# DEVELOPMENT FACILITATIVE TEAM (DFT)

## Code Enforcement Comments

**PR-2023-008710**

**SP-2025-00082 – SITE PLAN DFT**

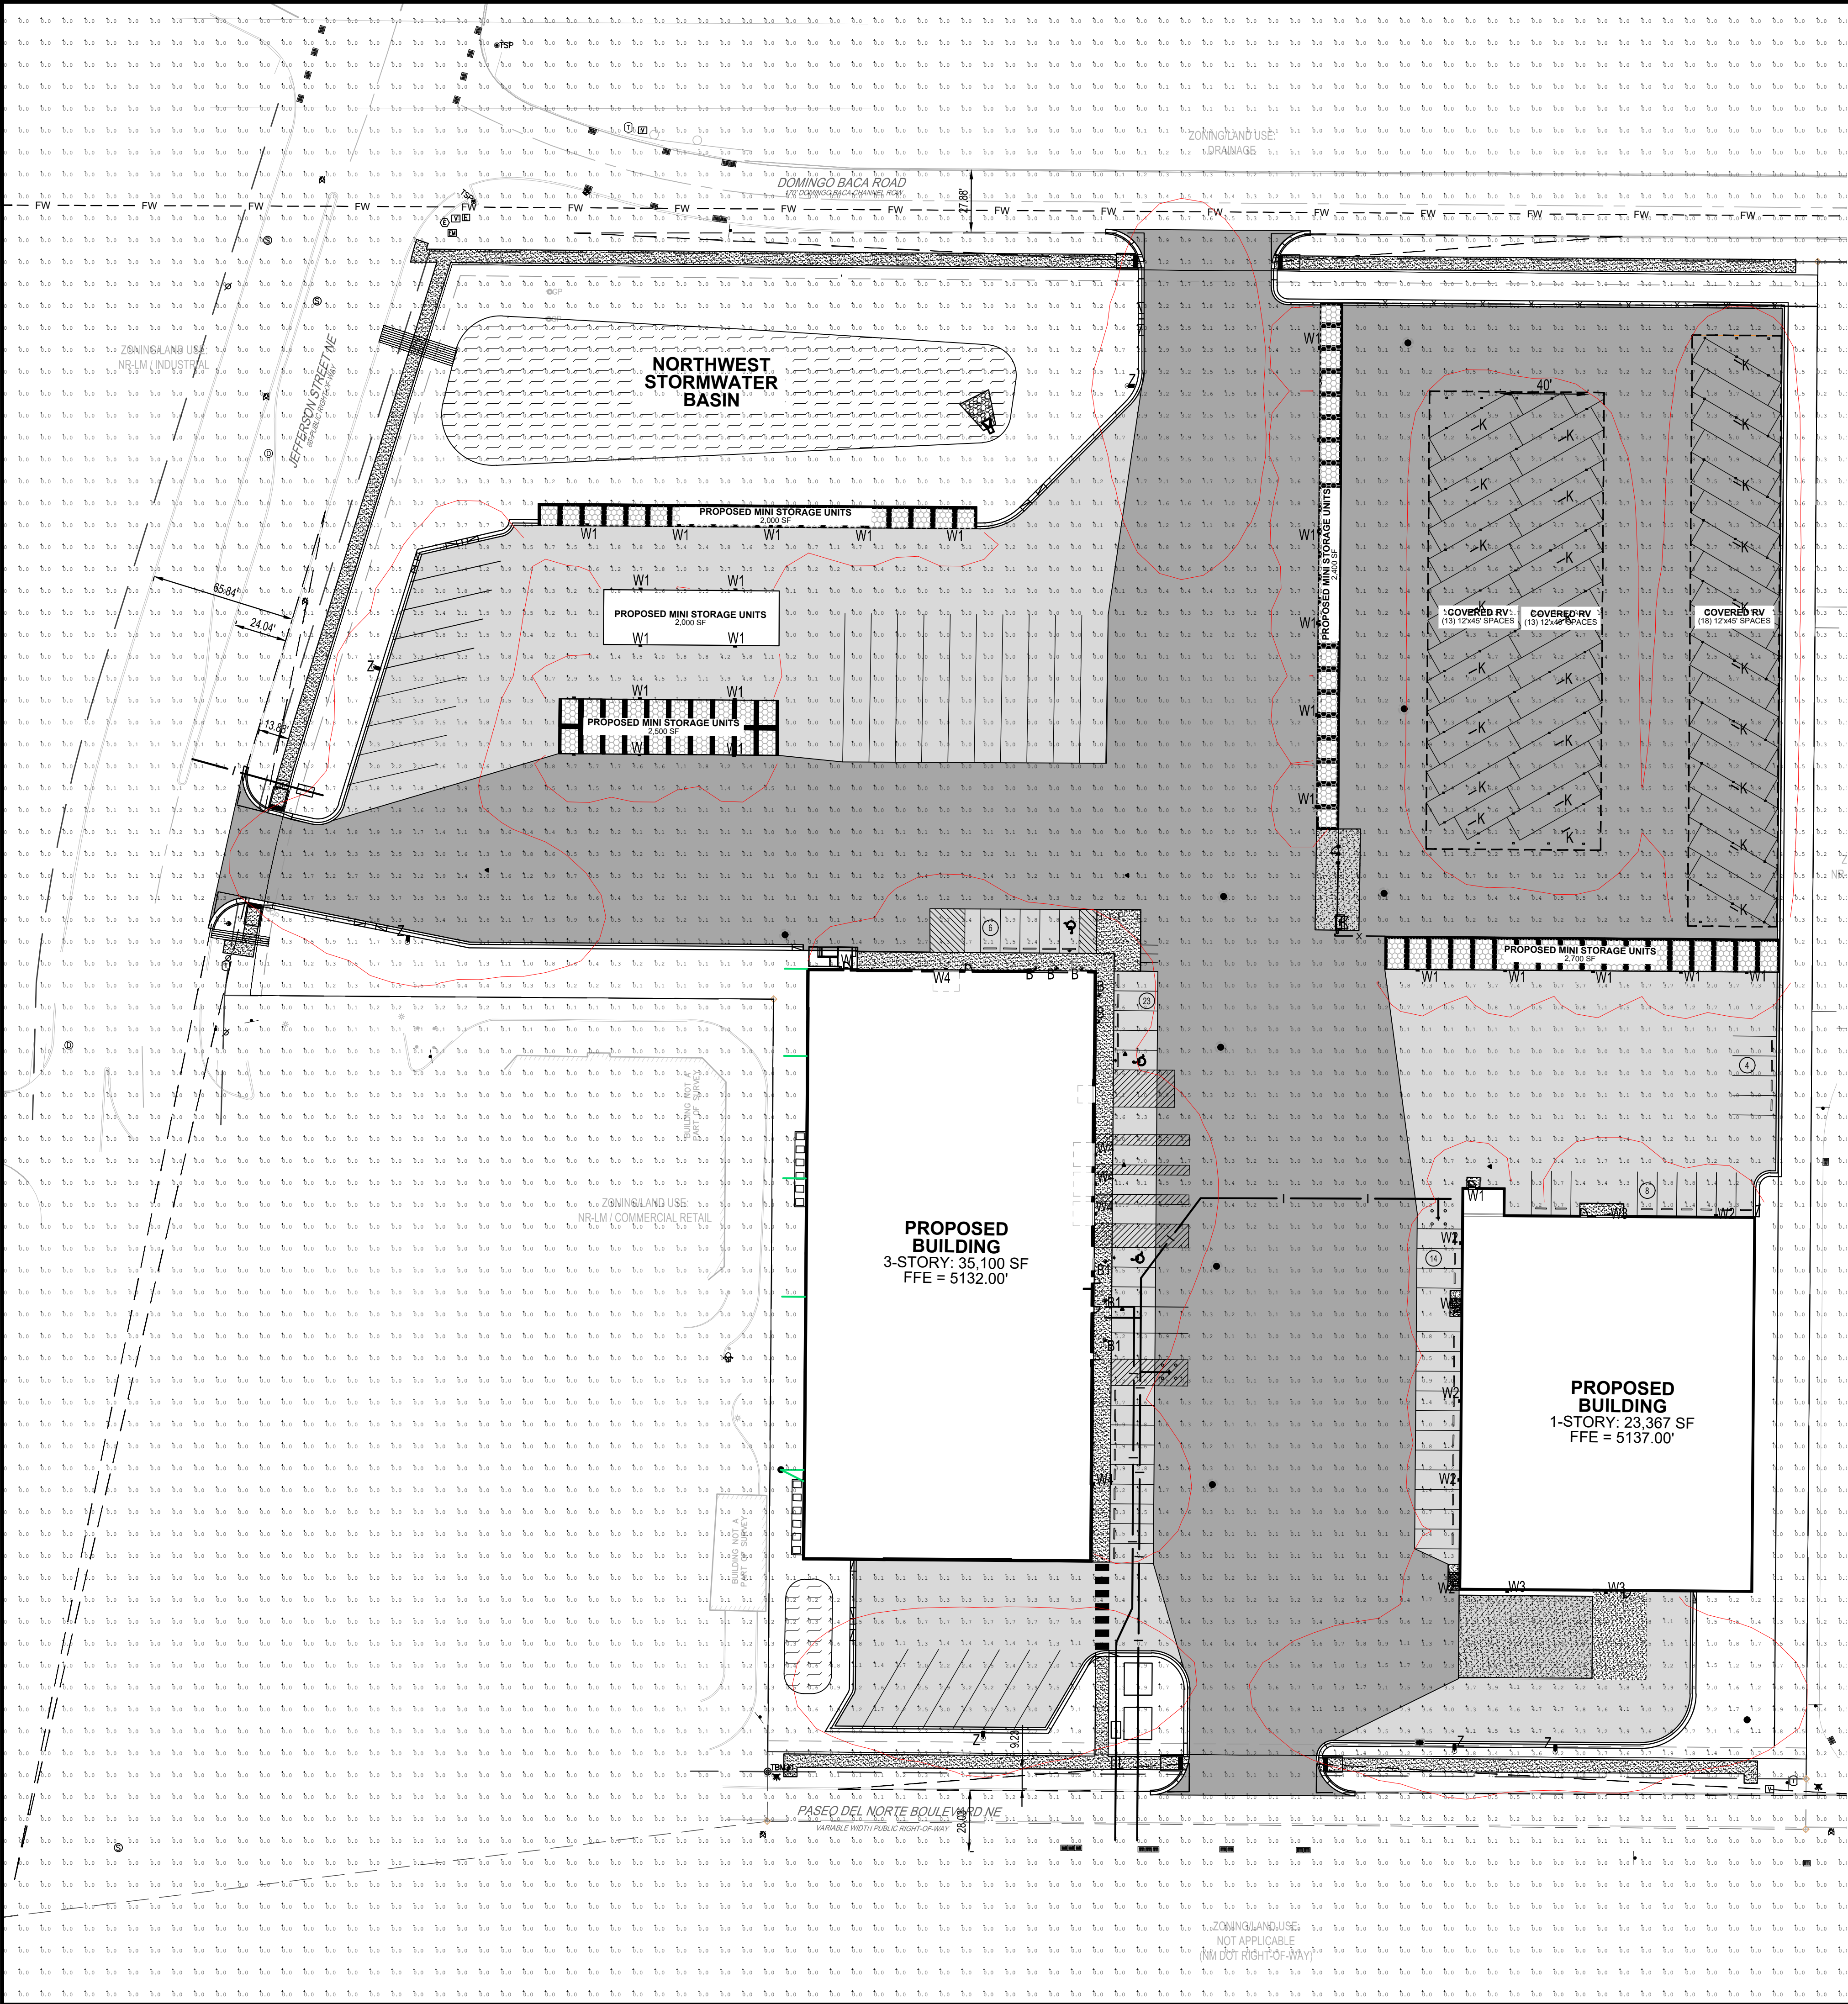
3. **Lighting:** Insufficient information provided on light fixtures to show compliance with IDO 5-8(E). Provide light fixture types/detail sheets to show how the light fixtures meet required cut-off angle requirements for building mounted and pole mounted lighting. *Please see the excerpt from IDO 5-8(E) at the end of the comments, below, regarding cutoff and shielding.*

4. **Lighting:** Light pole heights are limited to 20 feet as per IDO 5-8, Table 5-8-1. There is one light pole shown as 25 ft in height, with incorrect justification note on photometric lighting plan referencing it in the Commercial district. However, the Commercial district in Lighting Table 5-8-1 does not include allowable uses in the Offices and Services subcategory of Table 4-2-1, which would include Self-Storage. See the highlighted excerpt of Table 5-8-1 below, showing which category applies to this property, accordingly.

5. Lighting: The photometric site plan given does not show compliance with light trespass requirements at the property line, as per IDO 5-8(F)(4) Light Trespass and Table 5-8-3.
- A. Property is designated as an LZ-1 light zone, as per Table 5-8-2, section 5-8(F).
- B. The photometric lighting site plan should show the light trespass measurements at the property line at no higher than 0.1 footcandle to confirm compliance with allowable light trespass. Please note the highlighted portion of IDO 5-8(F)(4)(c), below:

The photometric site plan shows multiple instances of the lighting exceeding the allowable level at the property line, and the lighting plan must be adjusted to bring it into compliance.
